Your Ref: OWPC22414
Our Ref: FP/42/19/DOC 15-02-2019
Please ask for:
Mr S Davis

Approval of details reserved by condition imposed under ref FP/171/18/PL relating to
Condition Nos 5,6,7,8,9,10,11,12,13,14 & 24.

Land off Stanhorn Grove Stanhorn Grove

scheme: Land West of Stanhorn Grove,
Felpham
client: Worthing Homes
drawing: Tree Protection Plan
date: October 2018
scale: 1:200@A1
dwg no: PRI21588-03
drawn: RA checked: MW

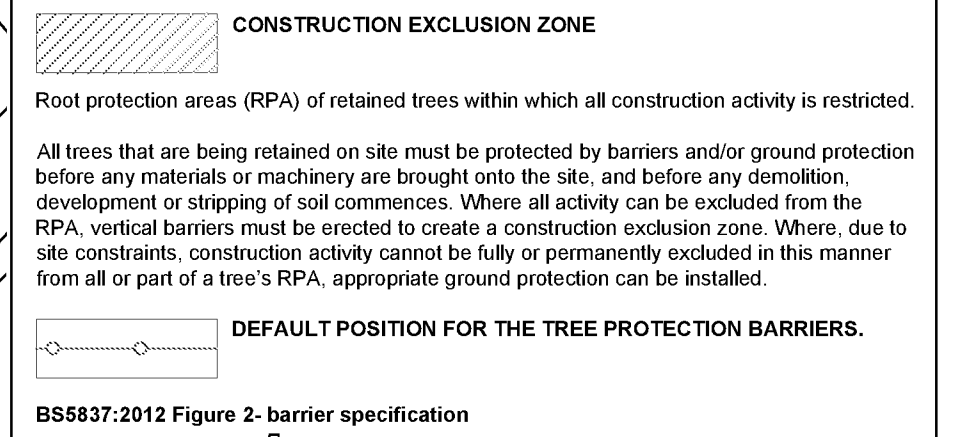
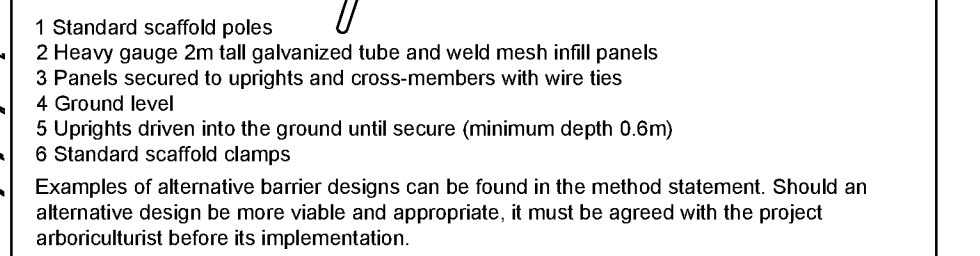
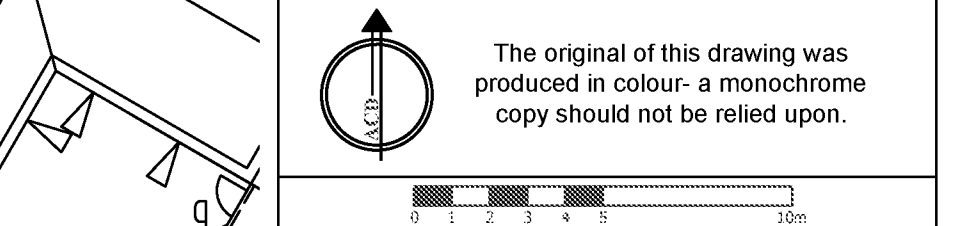
*Please note that the recent surgery to T7 (as per planning correspondence 24/04/19) has
resulted in the loss of the entire lowest limb of the tree (as shown in the supplied picture.
This is far more than the indicated 1.5M reduction.*
